Application No: WA/50/20/RES
Site Address: Former Lanes End House West Walberton Lane Walberton BN18 0QS
Description of works: Approval of reserved matters following outline consent WA/26/18/OUT for appearance, landscaping, layout & scale for the demolition of 1 No. dwelling & the erection of 6 No. dwellings (resubmission following WA/7/19/RES).

Thank you for your internet representation made on 29th October 2020 which has been recorded as an objection with the comments as follows:

PLOTS 1 AND 2 FLOOR PLANS AND ELEVATIONS

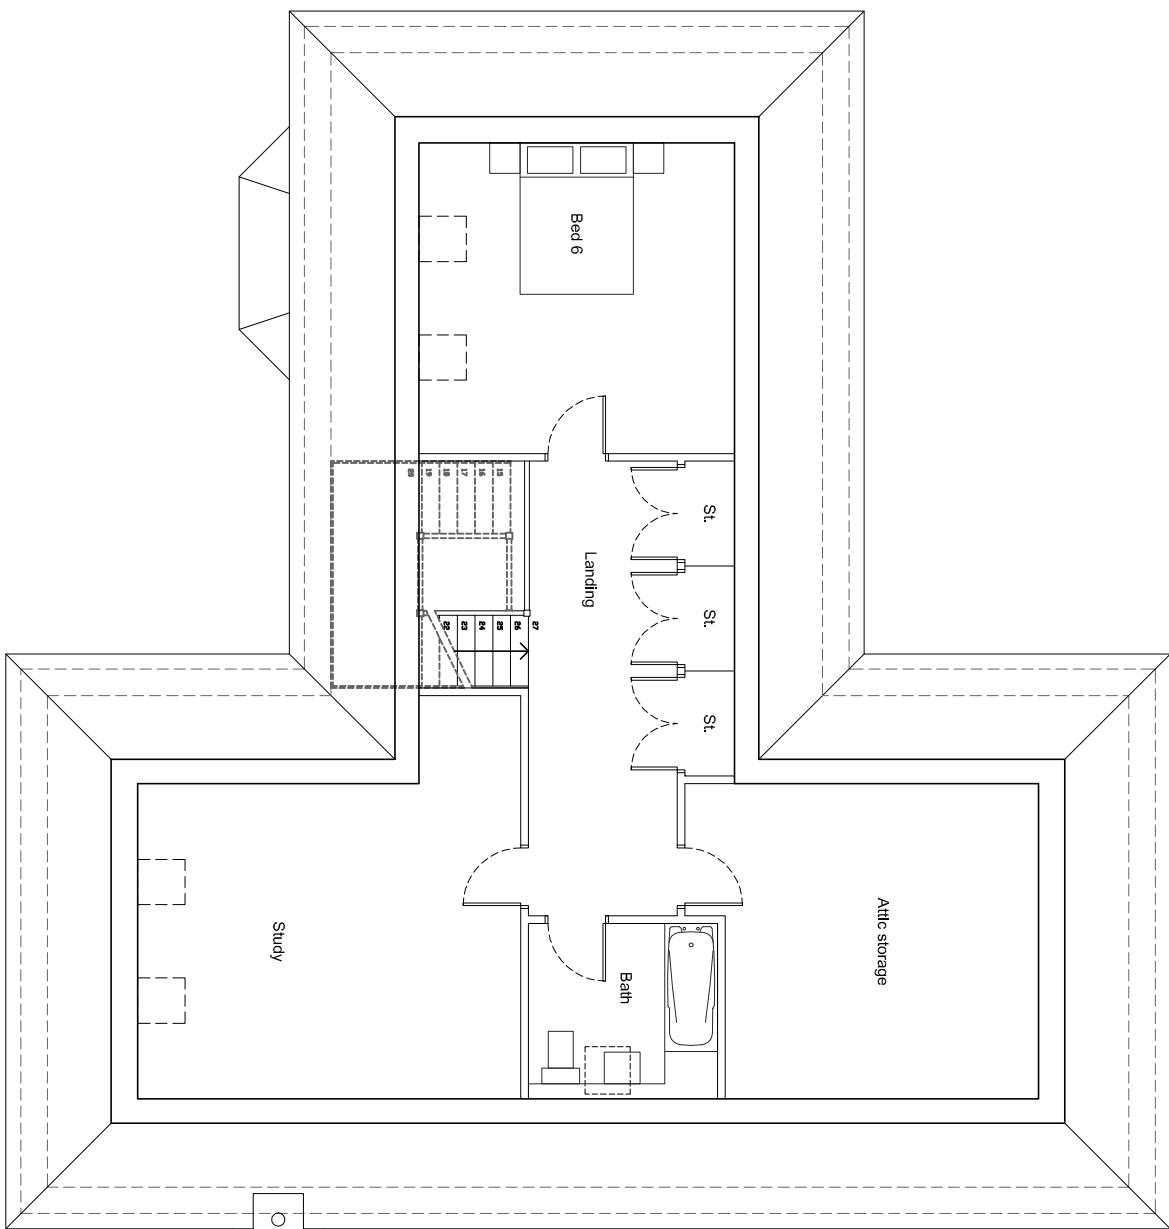
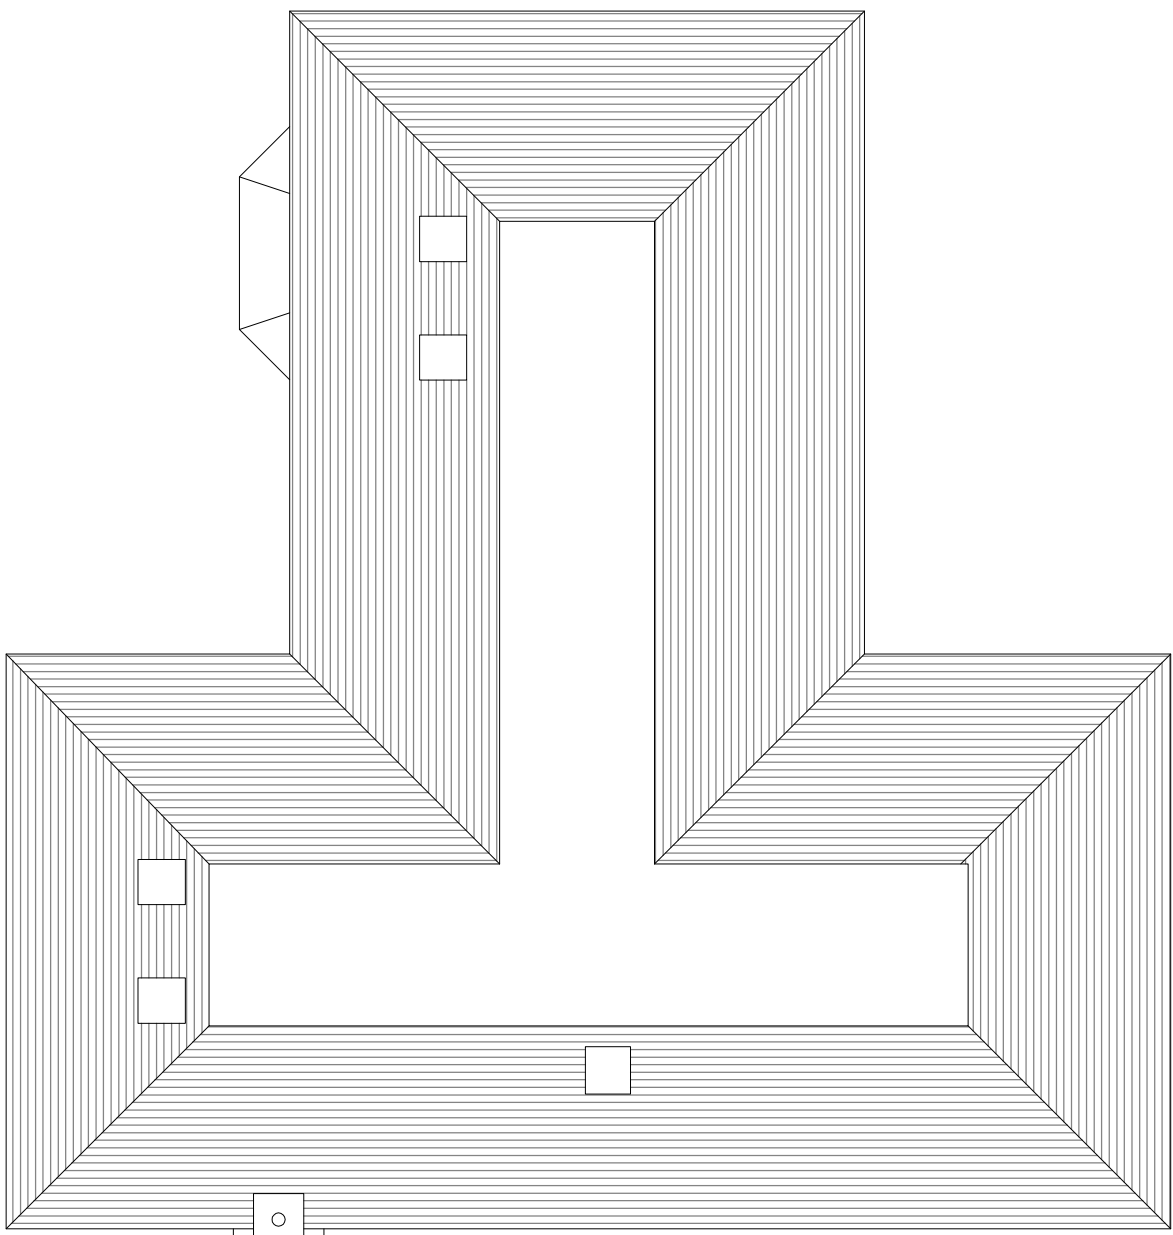
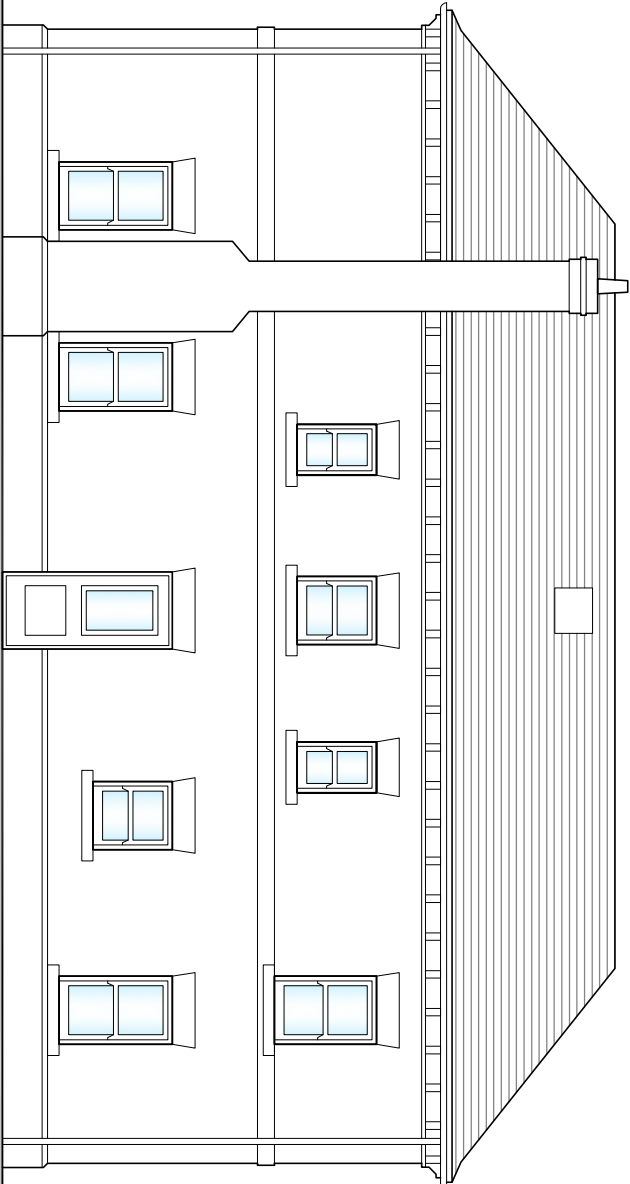
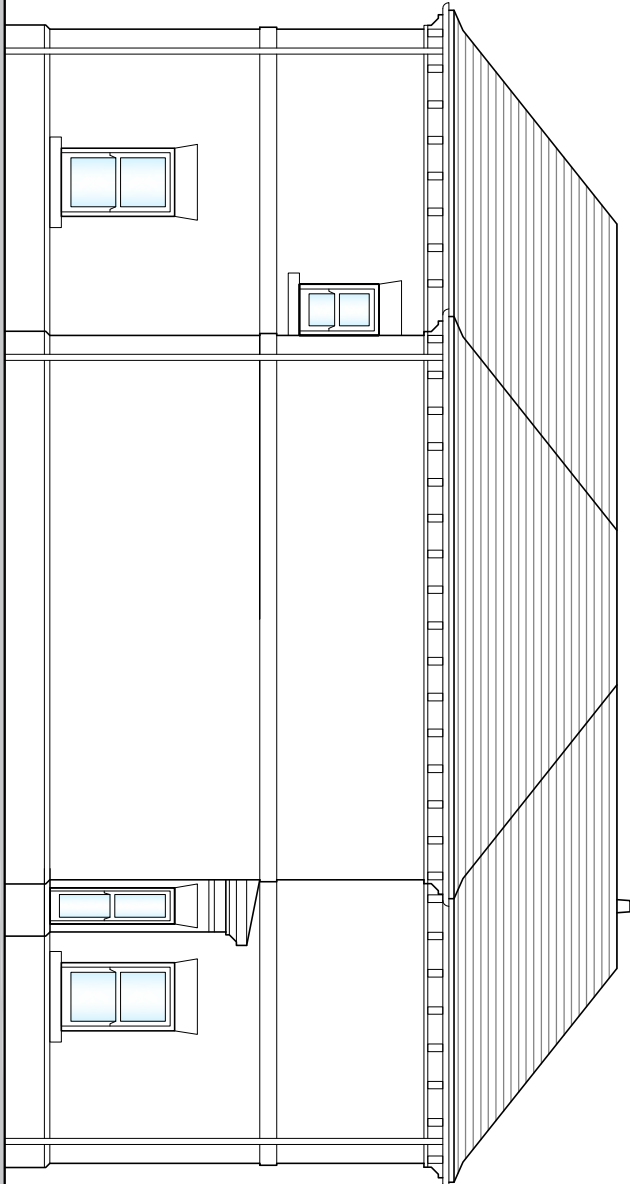
1. 3 story town house properties are totally out of keeping with the area.
2. 3rd storey windows of House 1 invade privacy of White Cottage. They will overlook directly into the bedrooms and the garden of White Cottage.
3. Garages 01 and 03 are too near to the White Cottage boundary. Will massively reduce the value of White Cottage.
4. House 03 is much too close to the boundary. Plan is marked as 8811mm from boundary but this is NOT the closest point to the boundary.
5. Site Comparison Elevation A-A 19-001 REVA is not accurate. This shows the proposed houses being approximately the same height as White Cottage. The proposed Street elevation A-A 19-001 REVA shows the proposed houses to be much taller.
6. Bats, owls, dragonflies, slow worms, grass snakes and newts are already home to this plot.
7. Too many houses (and garages) for size of plot.

8. The houses will overlook the properties either side, especially the three story houses, breaching the neighbours privacy.
